Rezoning Transportation Analysis

Petition Number: 2020-173

General Location Identifier: Tax ID 02919113

Date	Description
12-28-20	First Review (EL)

SCHEMATIC SITE PLAN

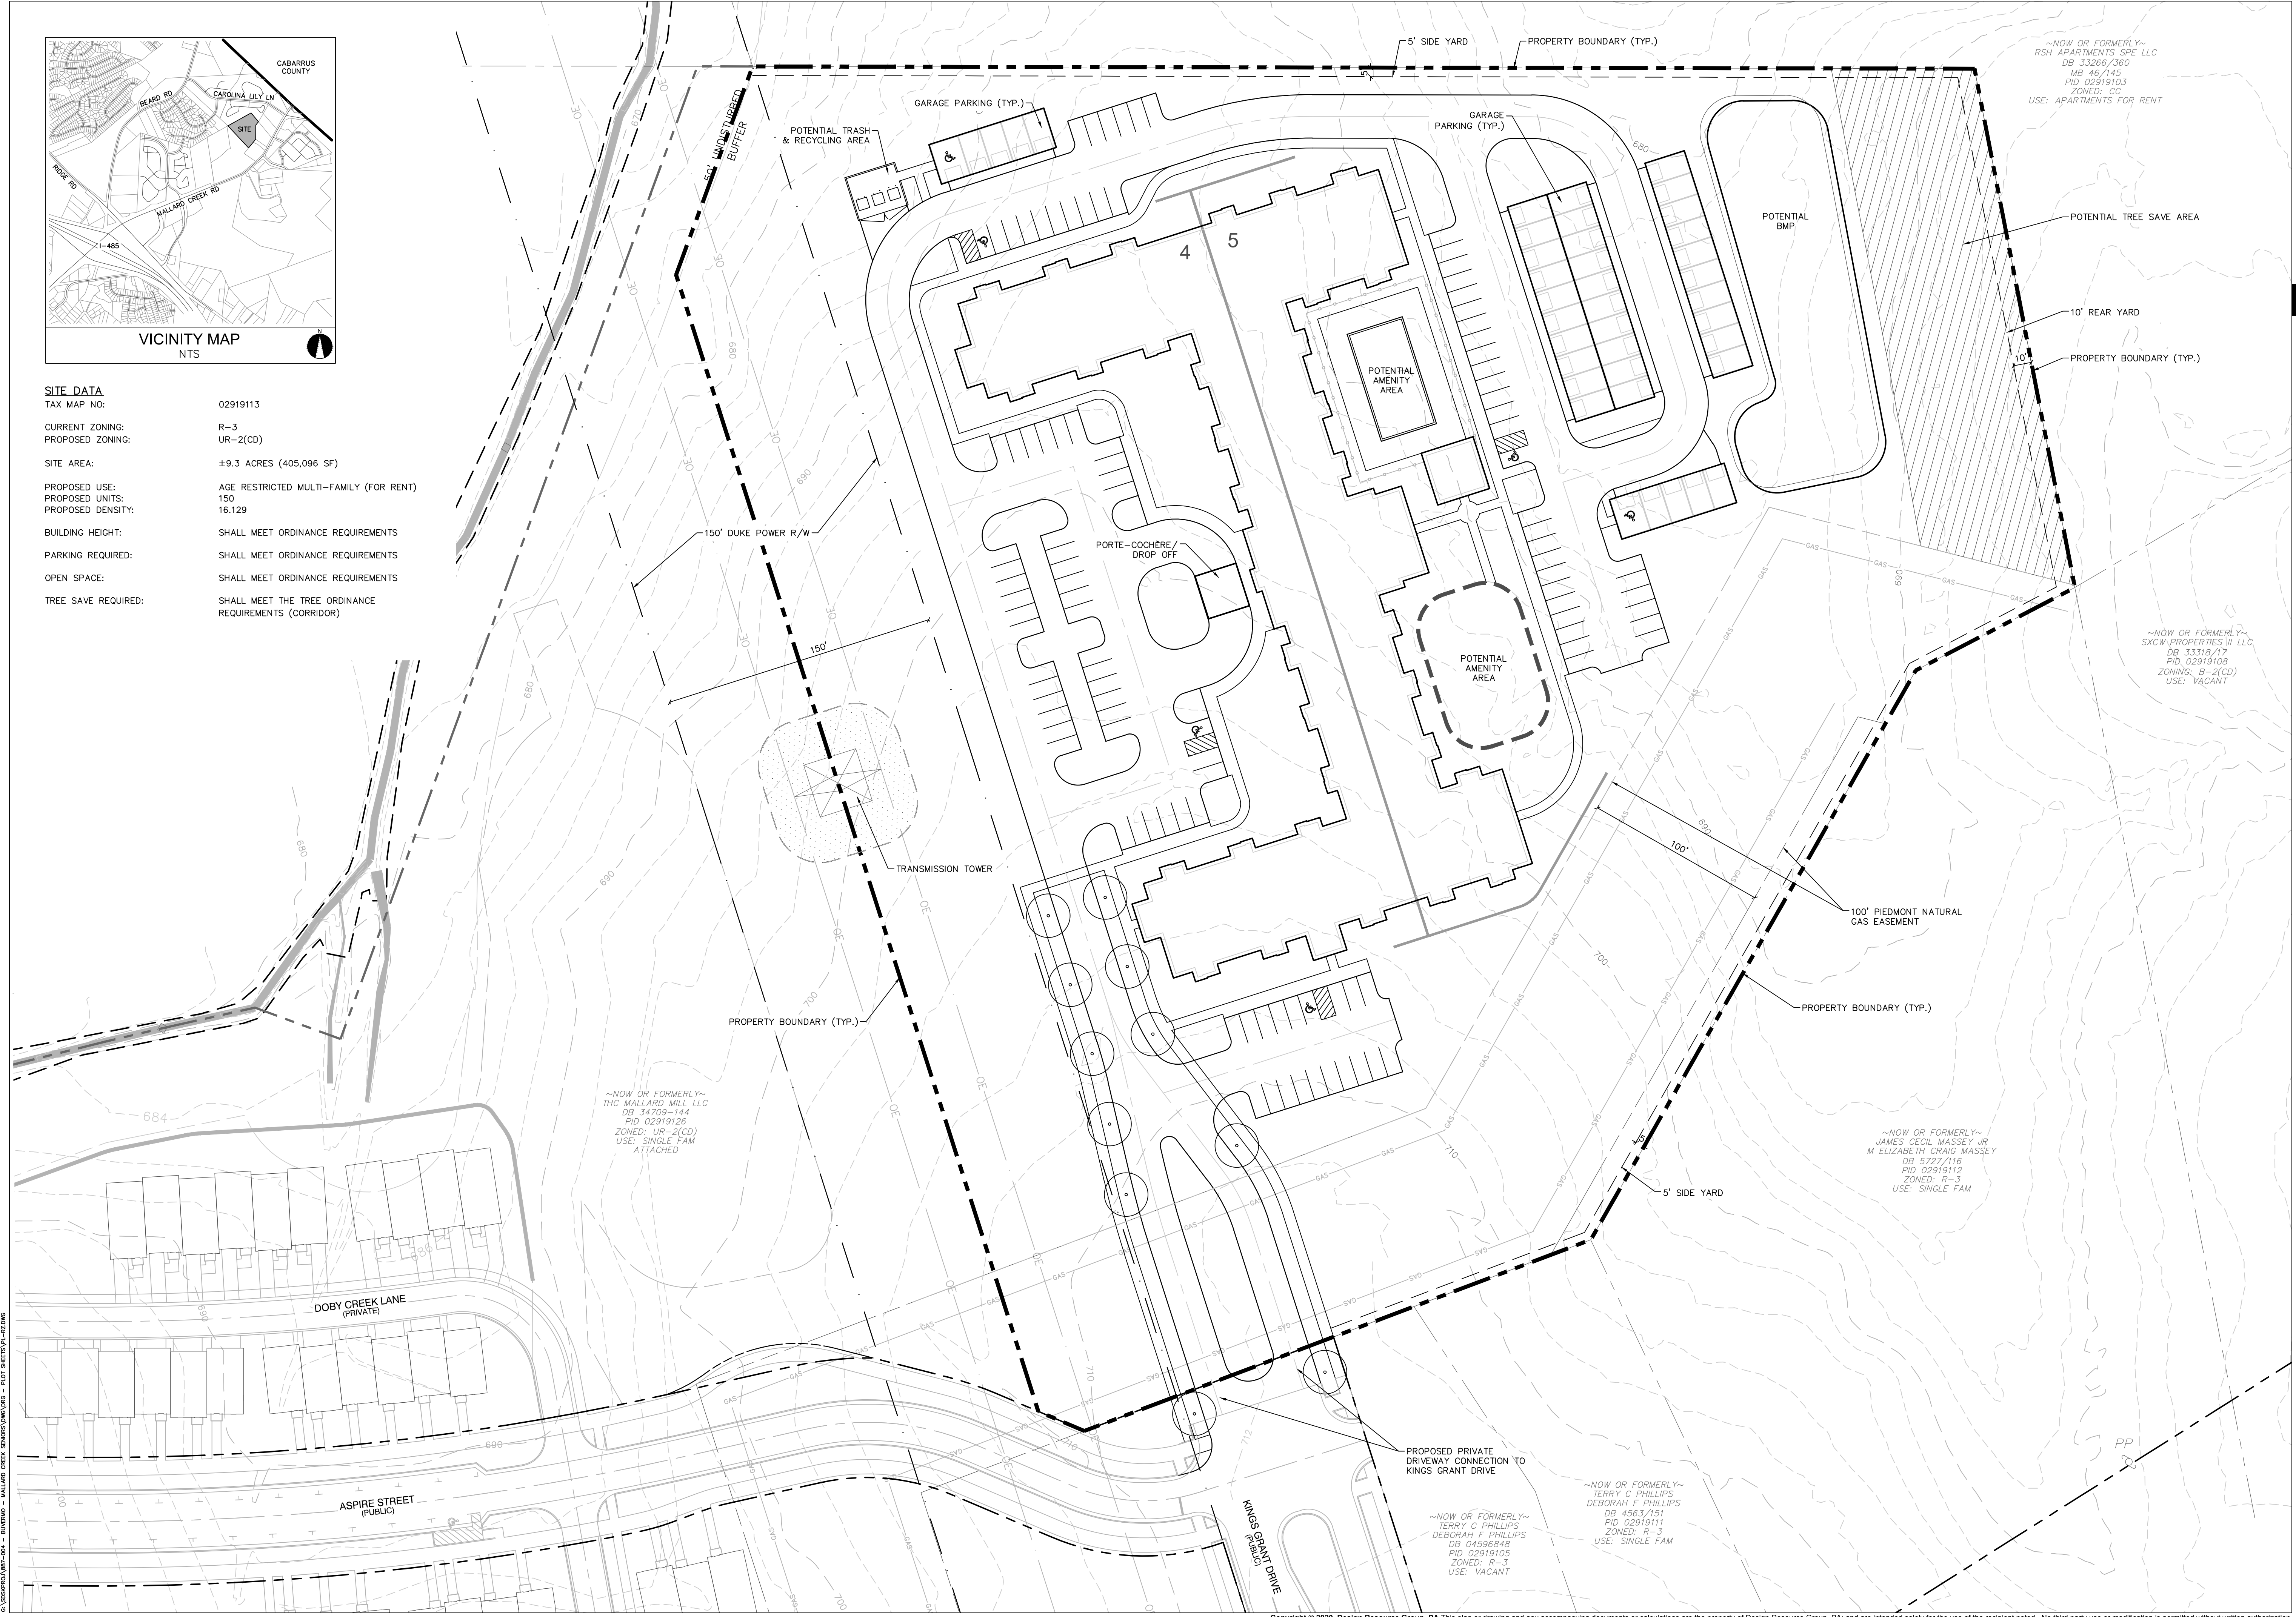
2. Revise site plan and conditional note(s) to commit to construct a public street extension from Kings Grant Drive, for a future connection to Appledale Drive/Carolina Lily Lane.

3. The proposed dwelling units exceeds 12 per acre. Per Chapter 20 Subdivision ordinance, site plan and conditional note(s) revisions are needed to commit to construct an 8-foot planting strip and 8-foot sidewalk along the requested Kings Grant Drive extension. The wider sidewalk also meets the Charlotte WALKS Policy.

Reference (CLDSM standard detail U-03A) for street typical. Curb extensions for on-street parking will not be required along the road frontage with the existing power easement on-site.

4. In coordination with NCDOT, revise site plan and conditional note(s) to clarify how the proposed access will be provided to this rezoning petition's landlocked parcel, if approved **SDRMF-2019-00075 - Mallard Creek Townhomes**, within **rezoning petition 2018-067**, is not developed to provide access off the proposed public Aspire Street.

Kings Grant Drive, north of Mallard Creek, will not tie-into Mallard Creek, since the NCDOT's State Transportation Improvement Program (STIP) U-6032 project has been delayed for construction until 2025. STIP U-6032's scope will improve the Kings Grant Drive and Mallard Creek Road intersection with a signal. Kings Grant Drive improvements, to be installed by **Mallard Creek Townhomes**, north of Mallard Creek Road, will stop short of Mallard Creek Road as an interim condition.

NCDOT will require interim improvements on Mallard Creek Road, if the petitioner desires access off Kings Grant Drive should the proposed Aspire Street not be constructed by others. CDOT recommends the petitioner coordinate with NCDOT to determine the required interim improvements on Mallard Creek Road as a plan for this scenario.
